DRAINAGE LETTER

LOT 11, ROLLING THUNDER BUSINESS PARK

County File No.: PPR-21-24

SUBJECT: Drainage Letter
Lot 11 Rolling Thunder Business Park

Scale 1" = 20'  
Contour Interval: 1'

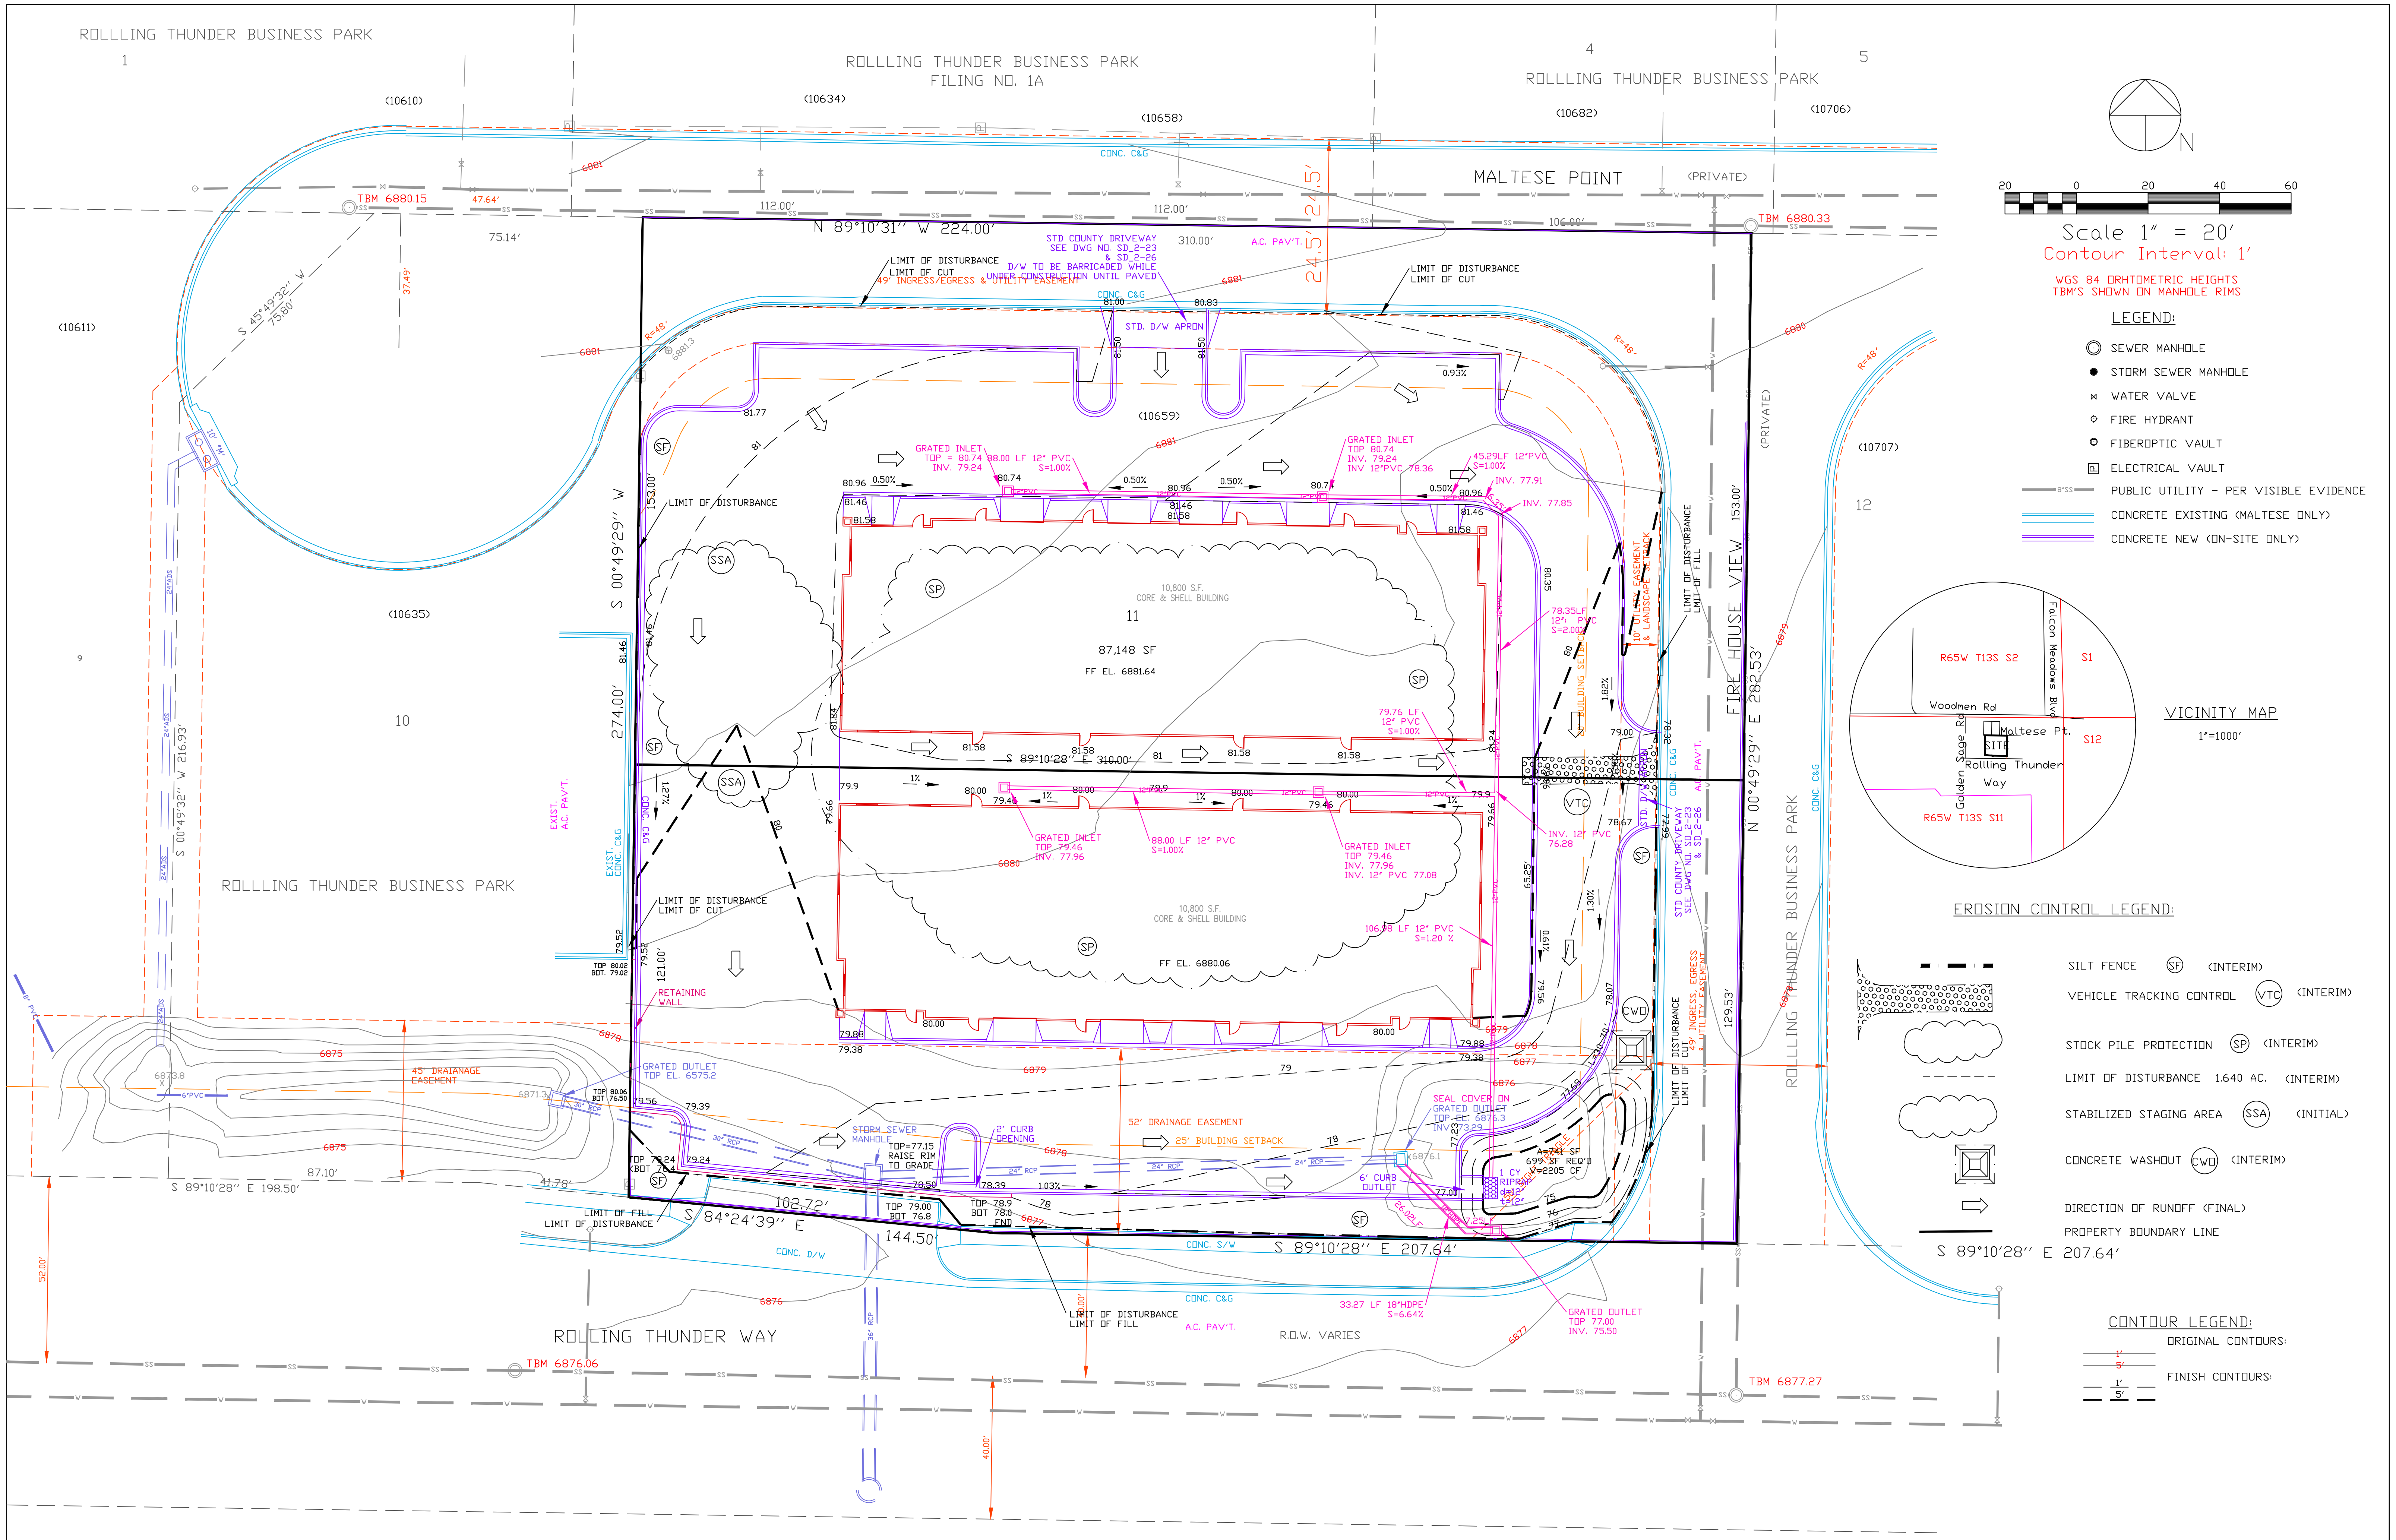
Based on landscaped area on site plan approx <12,000sqft recalculate your impervious area

Show or state that the impervious area and resultant flows to the sand basin pond are within the capacity of the 18inch HDPE pipe
